City of Portland, Maine - Building or Use Permit Application

Location of Construction: 314 Warren Ave	Owner Name: Baker Dwight P	Owner Address: 336 Warren Ave	Phone: 207 797-3159
Business Name: n/a	Contractor Name: J.M.H. Construction and Design	Contractor Address: Long Wharf Portland	Phone: 2074155783
Lessee/Buyer's Name n/a	Phone: n/a	Permit Type: Alterations - Commercial	Zone: B-4

BUILDING PERMIT REPORT

REASON FOR PERMIT: Repair rear wall

USE
SITE PLAN
DWIGHT D. BAKER
WARREN AVENUE
PORTLAND, MAINE

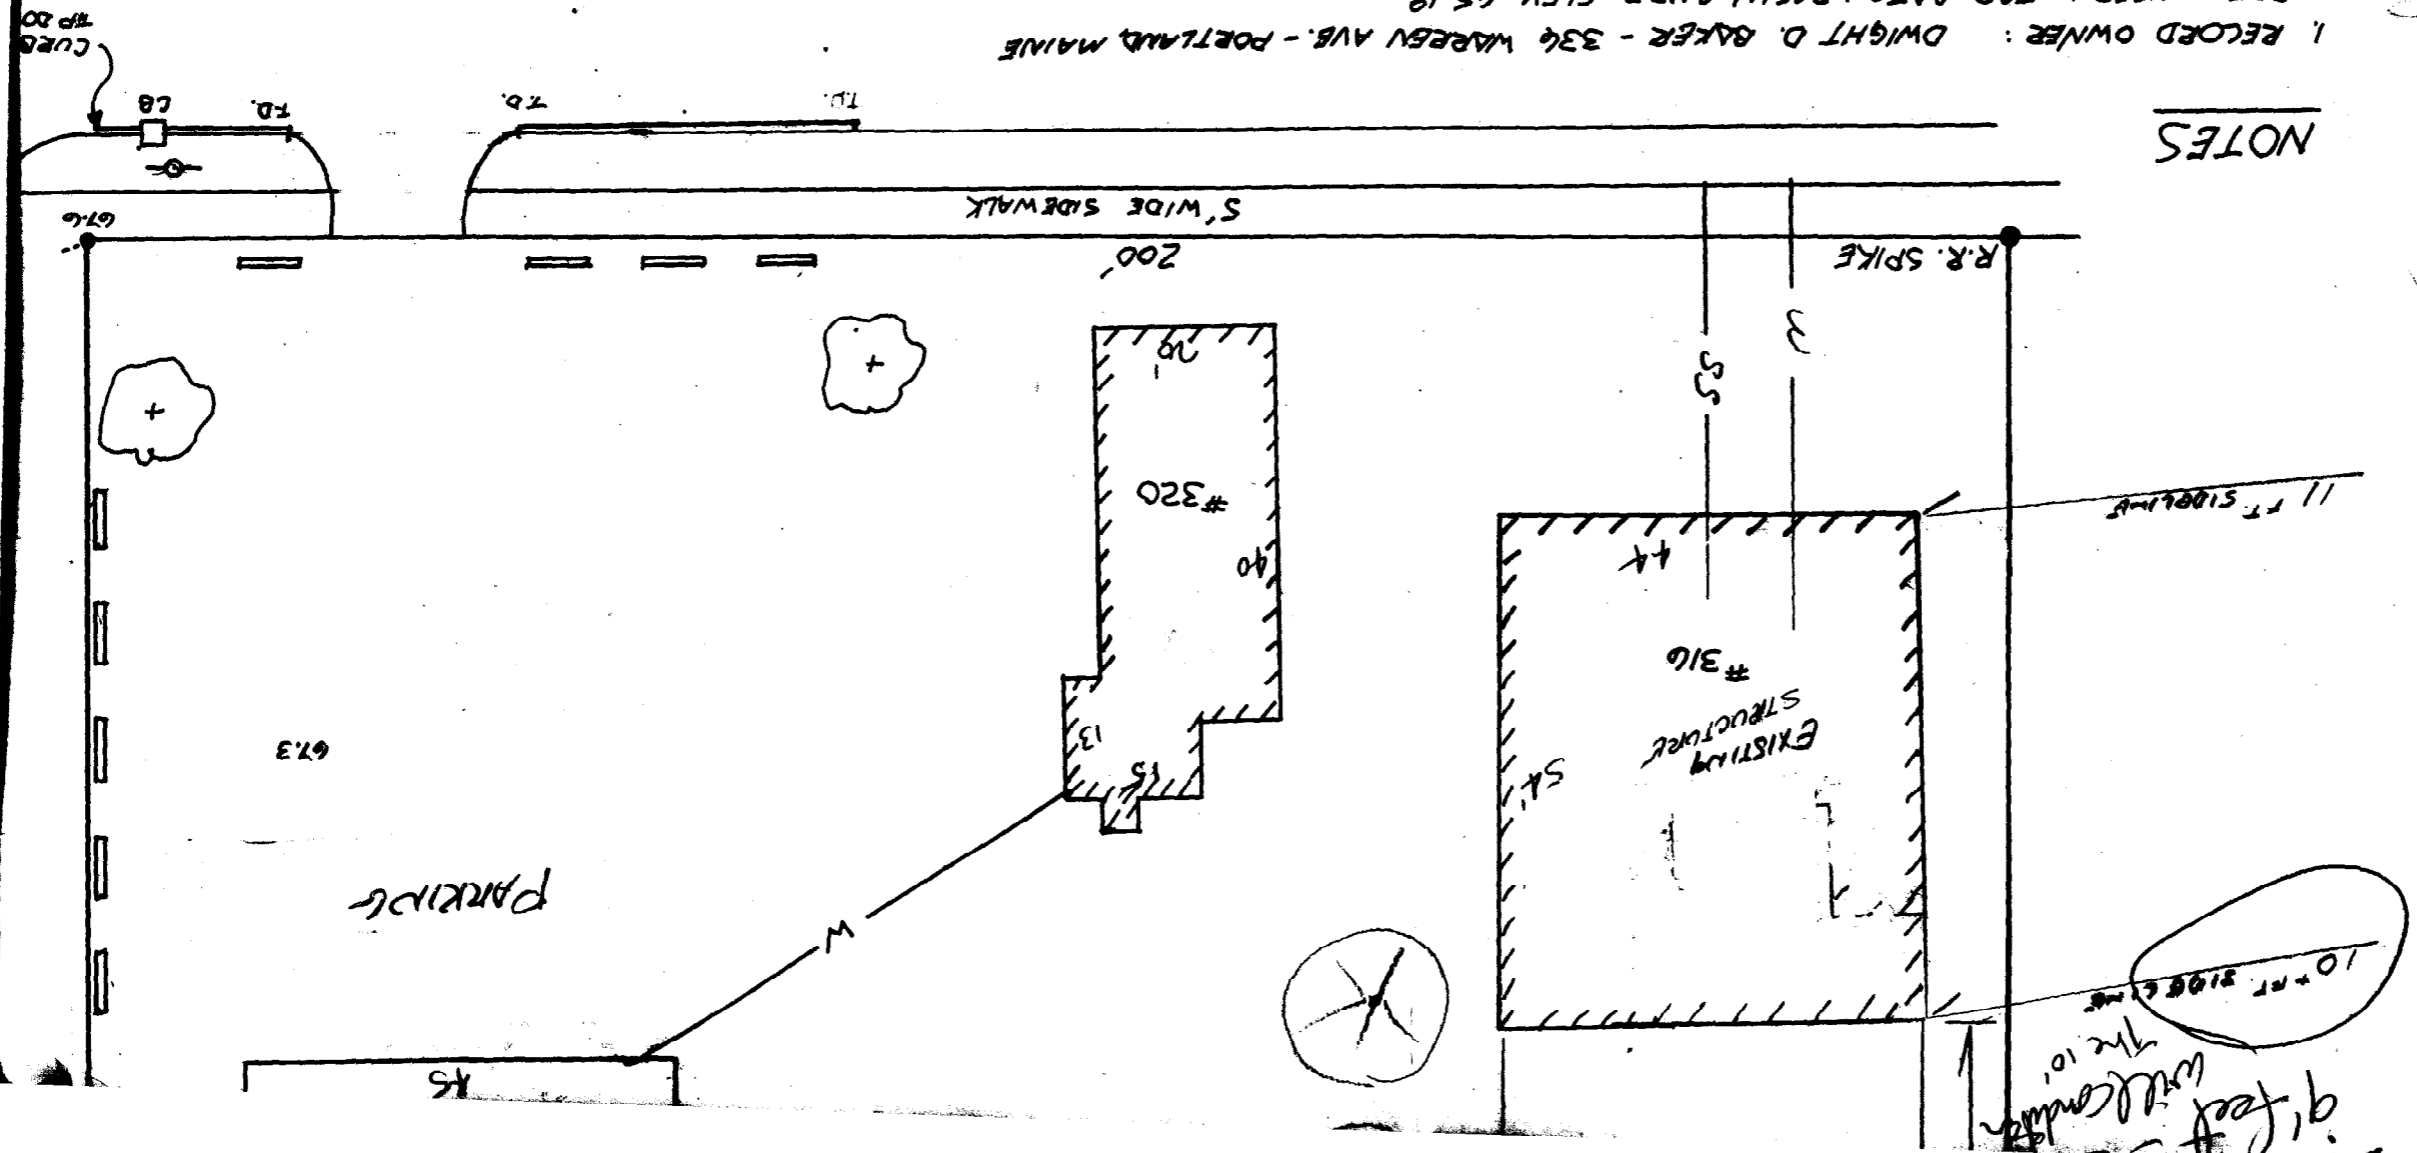
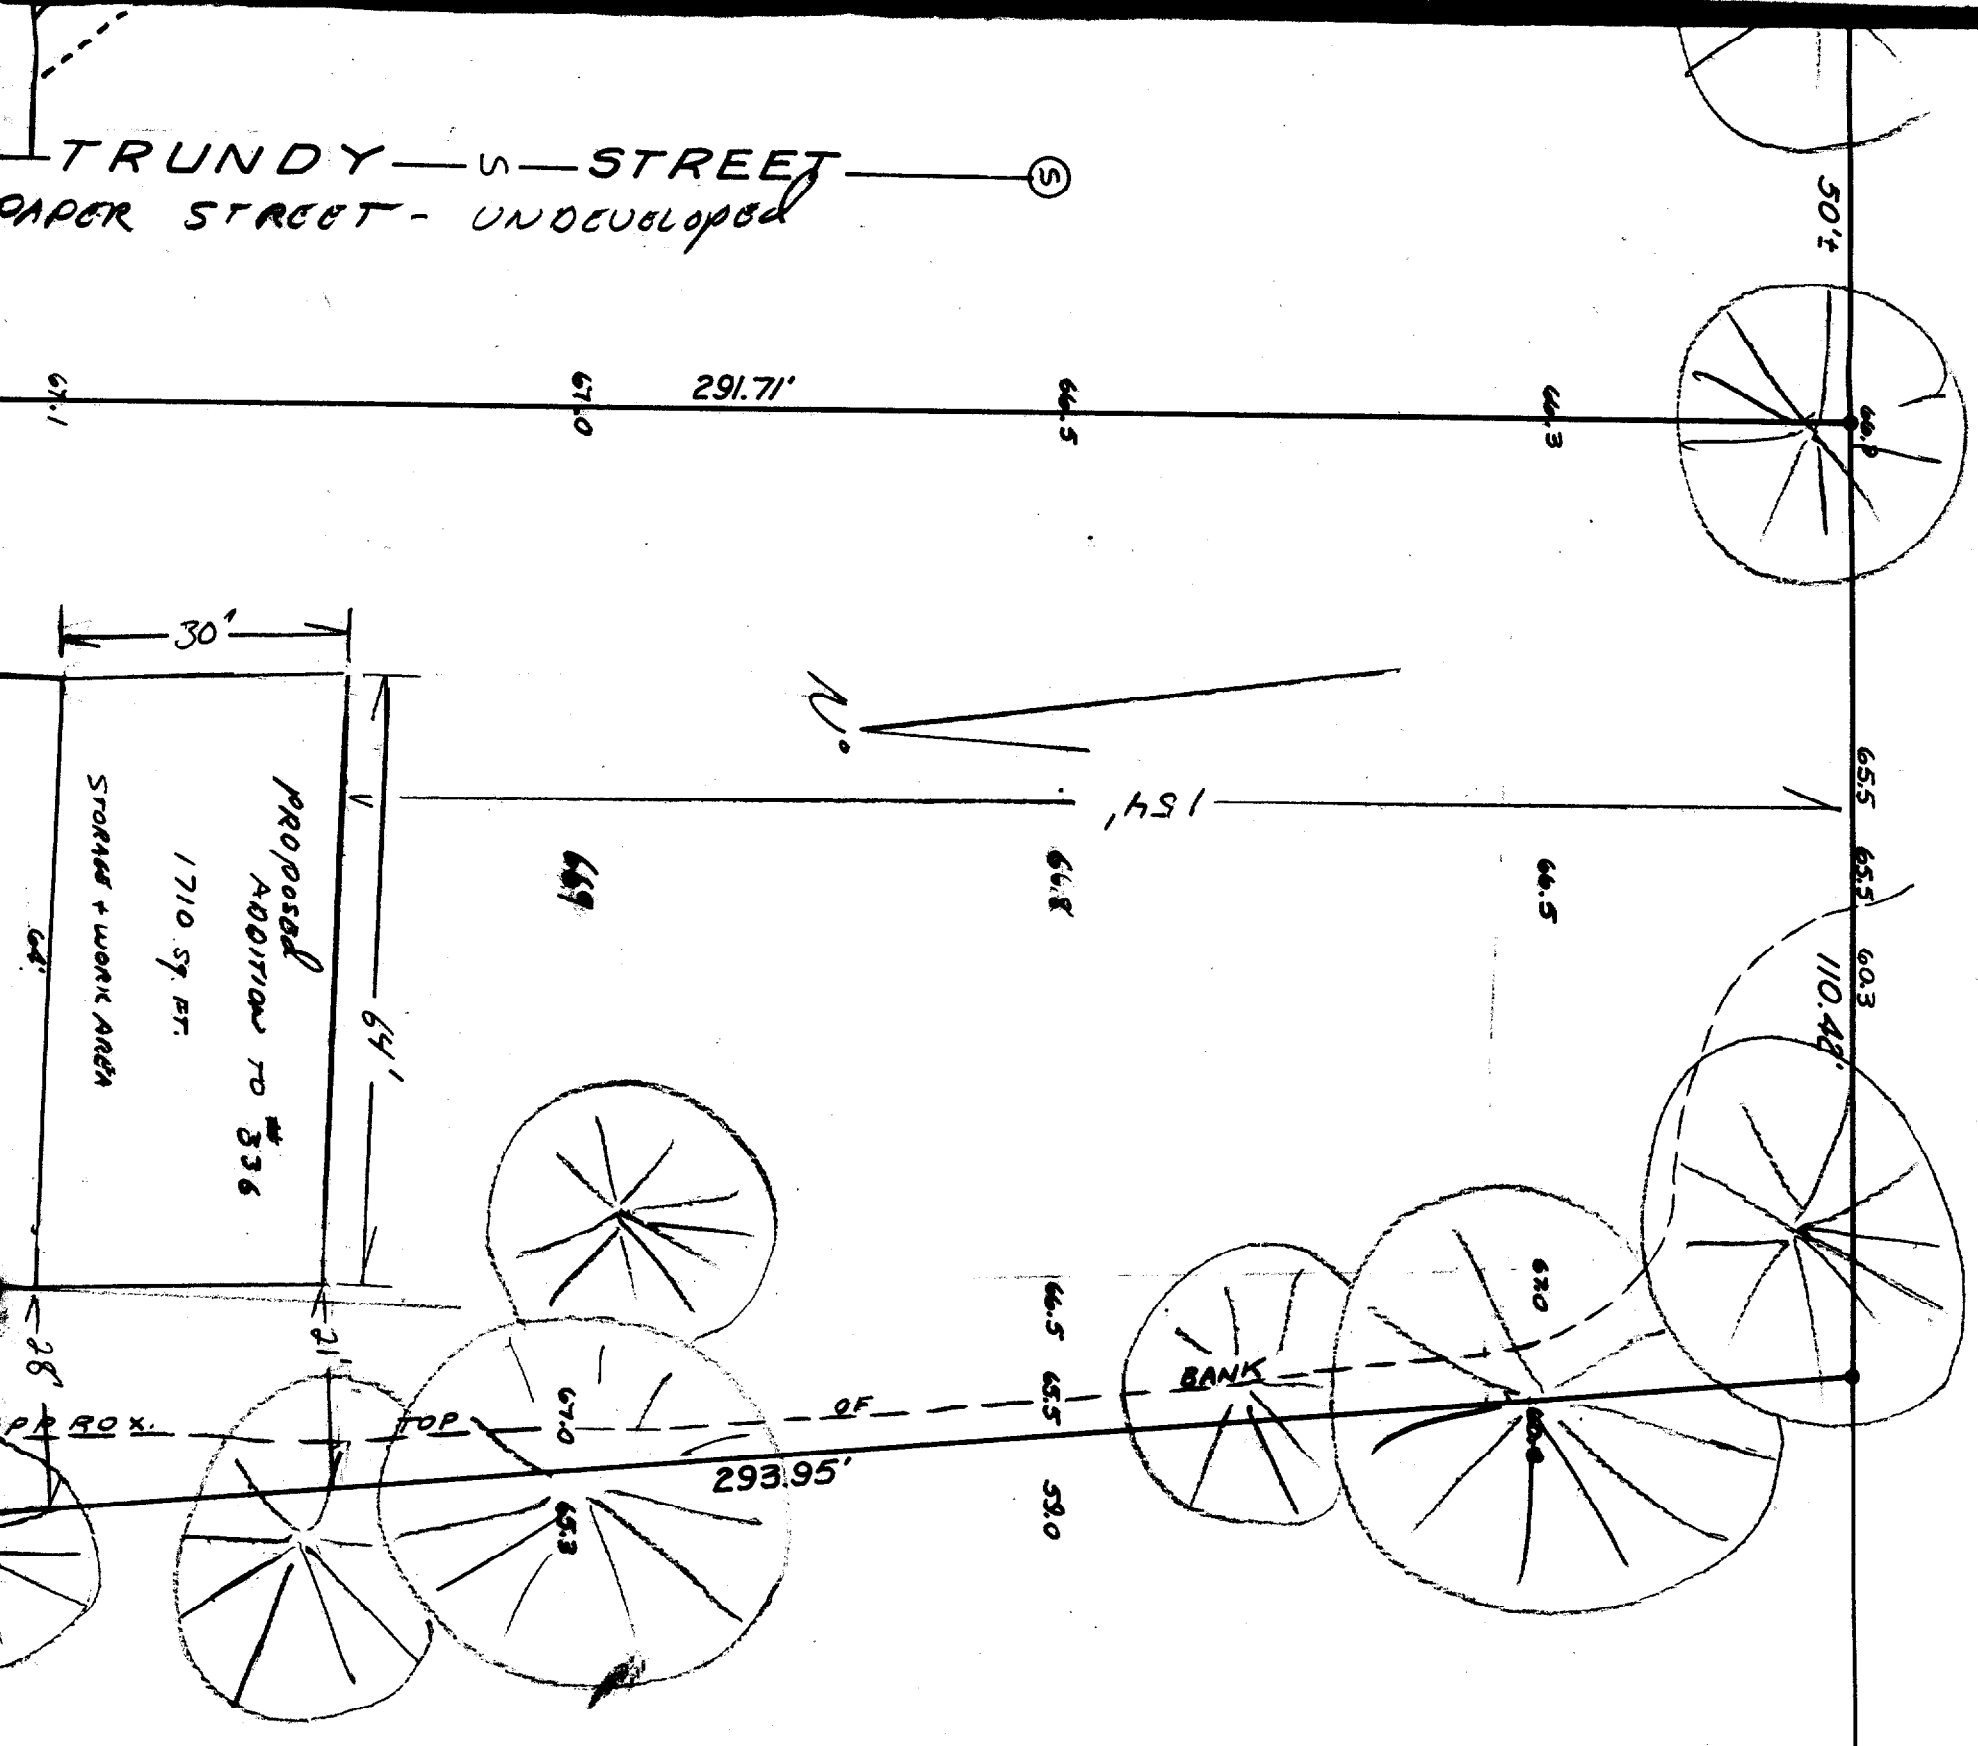
B-4 Zone
 10' req - 10' shown
 20' req - 60'+ shown
 N/A
 OK
